2 May 2013

**RE: Submission in Response to the EIS on the Proposed Watermark Coal Project
(Application Number SSD 4975)**

Figure 84
Key Road Midblock Capacity Diagram

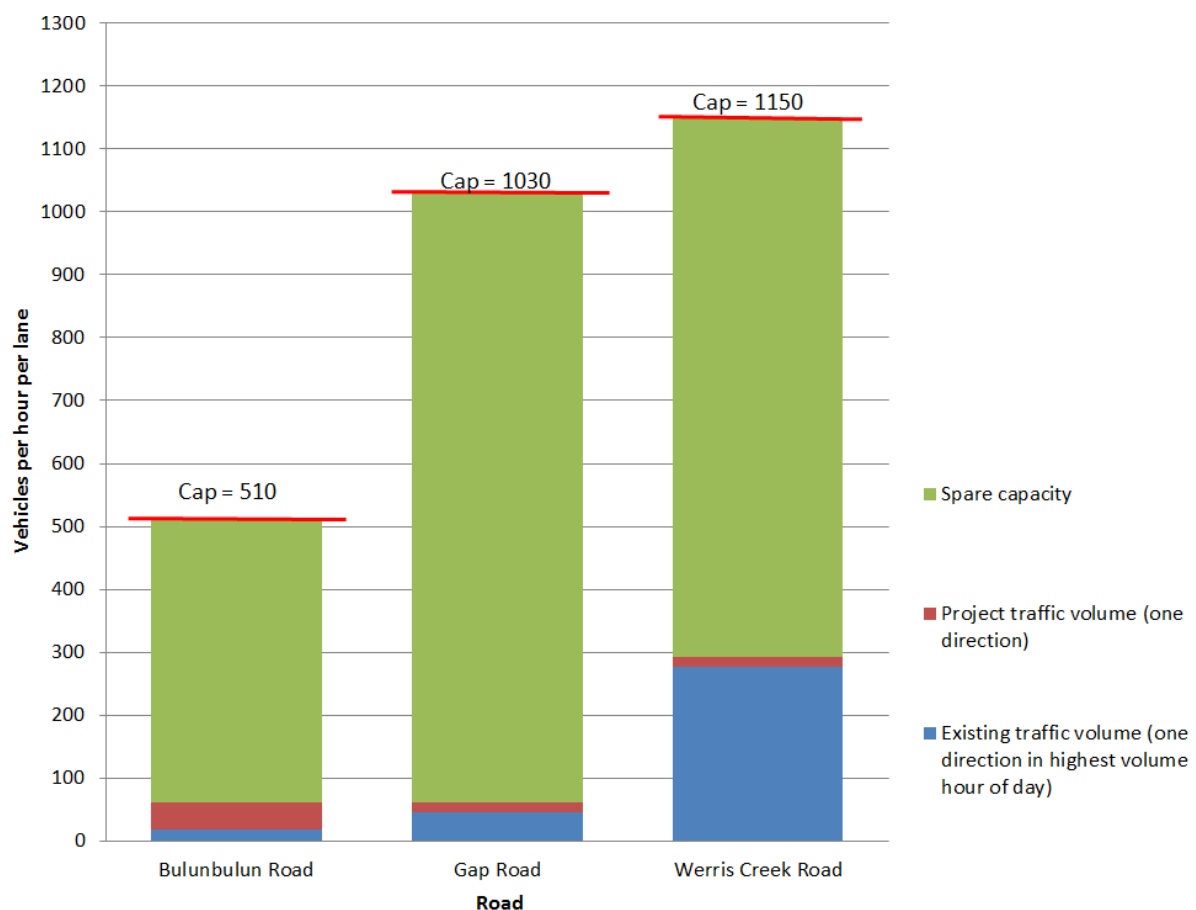
The traffic assessment (Appendix AB page 16) suggests that the Bulunbulun Road has spare capacity to absorb the additional traffic likely to be generated by the Project. Council considers that this road will be utilised by the employees, contractors and service providers based in Tamworth, as it is the shortest route to the Project site. As a consequence it will carry a heightened level of traffic that will significantly impact on the road's serviceability. It is Council's view that as a result of this traffic impact the road will trigger level D, resulting in the need for Bulunbulun Road to be bitumen sealed.

It is concerning that little attention appears to have been given to this issue in the EIS and where it is indicated "no data is available" (Appendix AB page 47). We note that although this issue was highlighted in Council's adequacy assessment of the EIS, to our knowledge there has been no baseline traffic counts undertaken in the months between the adequacy period and the exhibition of the EIS.

1. That Bulunbulun Road be reconstructed and bitumen sealed from the low level bridge at the Mooki River to the existing seal located at the boundary of the Liverpool Plains LGA, with a 9 m formation and 7 m seal consistent with Austroad design standards and subject to Council's approval.
2. That a detailed Traffic Assessment be undertaken for all Project related traffic on the following streets in Breeza:
 - a) Intersection of Bulunbulun Road and Maitland Street;
 - b) Intersection of Bulunbulun Road and Kamilaroi Highway;
 - c) Low Level Bridge at Mooki River (Maitland Street);
 - d) Maitland Street;
 - e) Intersection of Maitland Street and Hogarth Street;
 - f) Hogarth Street;
 - g) Rail Crossing (Hogarth Street) of North West Rail Line; and
 - h) Intersection of Hogarth Street and Kamilaroi Highway

Figure 32
Watermark Gully Post Mine Flood Level Impacts (2 Year ARI)

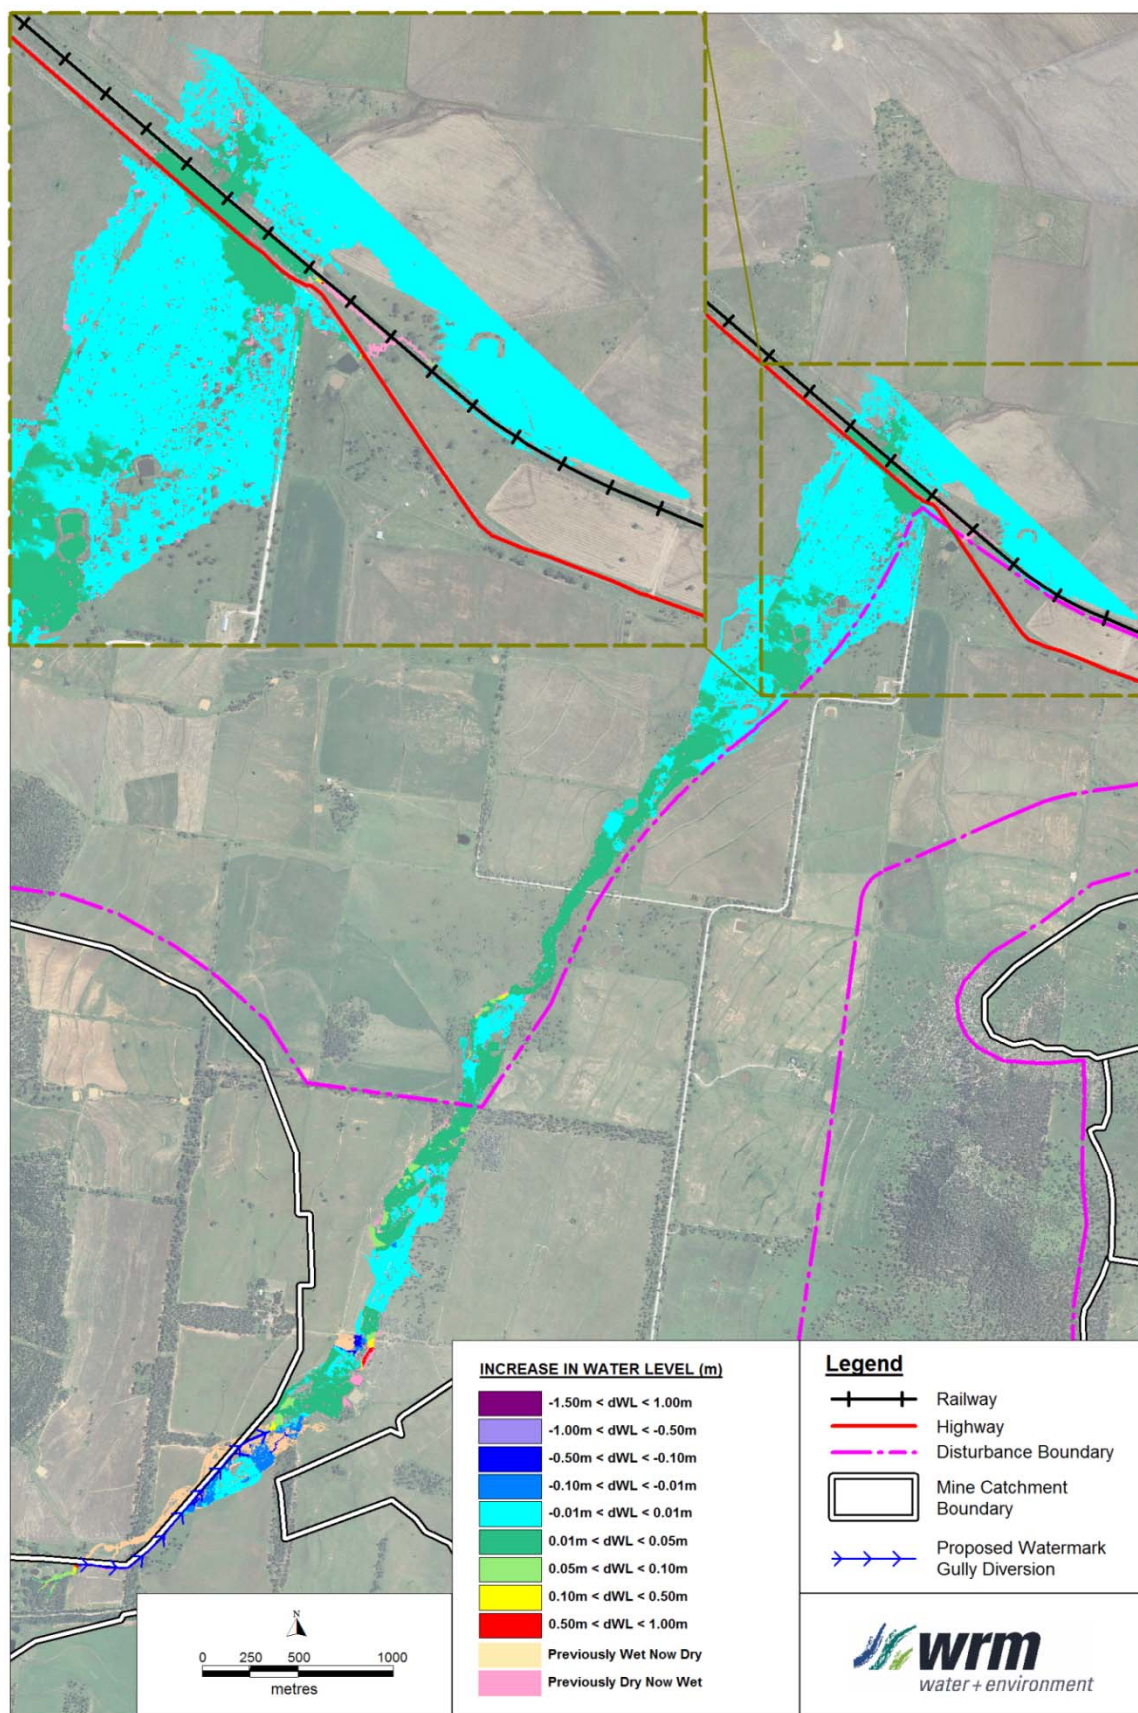
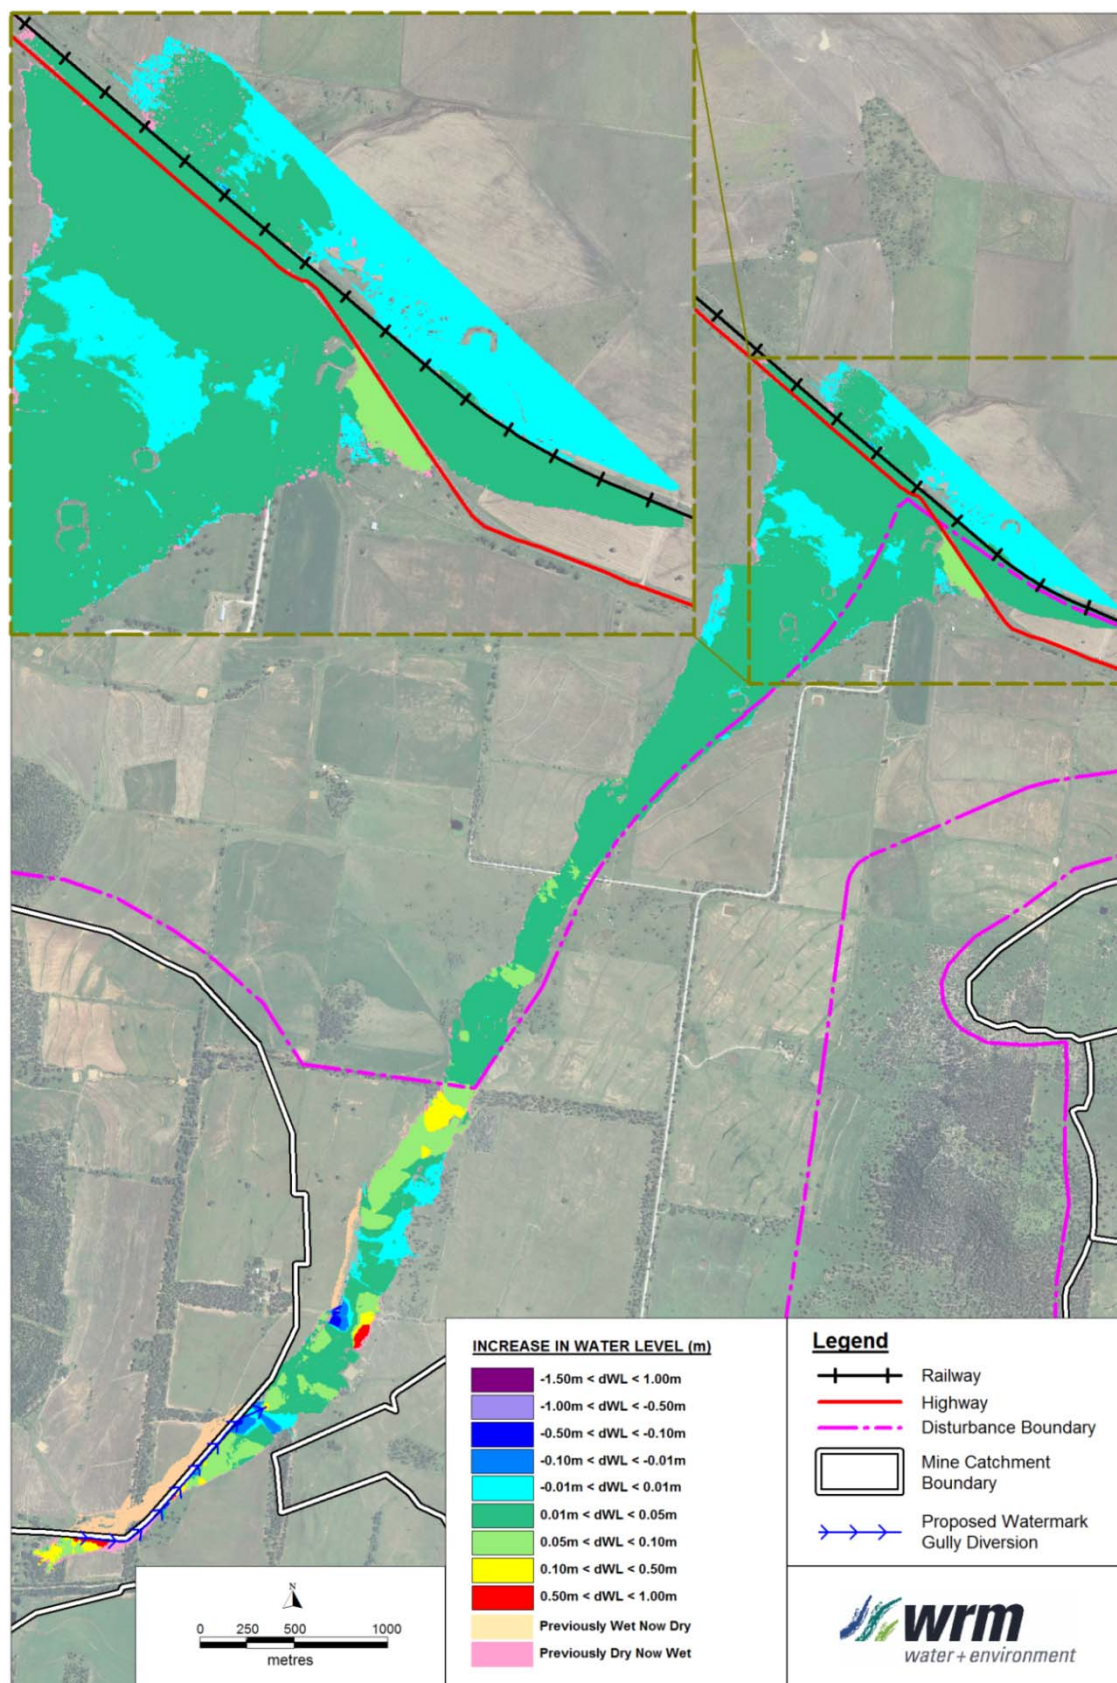
Council notes that the EIS predicts changes to the Watermark Gully catchment such that the surface runoff characteristics will change, leading to an increase in surface water flows. This outcome will increase flood heights and frequencies along Watermark Gully and increase the flood risks on the Kamilaroi Highway.

Appendix S (page121) indicates that "peak level floods" in the vicinity of the Kamilaroi Highway will increase by 0.09 metres after rehabilitation of the mine. Further at page 124 it predicts an increase of 19.2% of surface water flows in the Watermark Gully post mining. That is an increase from 26 ML/day to 31.6 ML/day post mining.

This is a major increase in flood peaks that will have significant impacts on the level of service provided by the Kamilaroi Highway, not to mention the implications for downstream agricultural activity.

1. That the Proponent reach agreement with Council and the Roads and Maritime Services regarding upgrading the Watermark Gully crossing on the Kamilaroi Highway.
2. That details are provided by the Proponent on other local roads that may be cut due to floodwaters and the traffic diversions proposed in response.
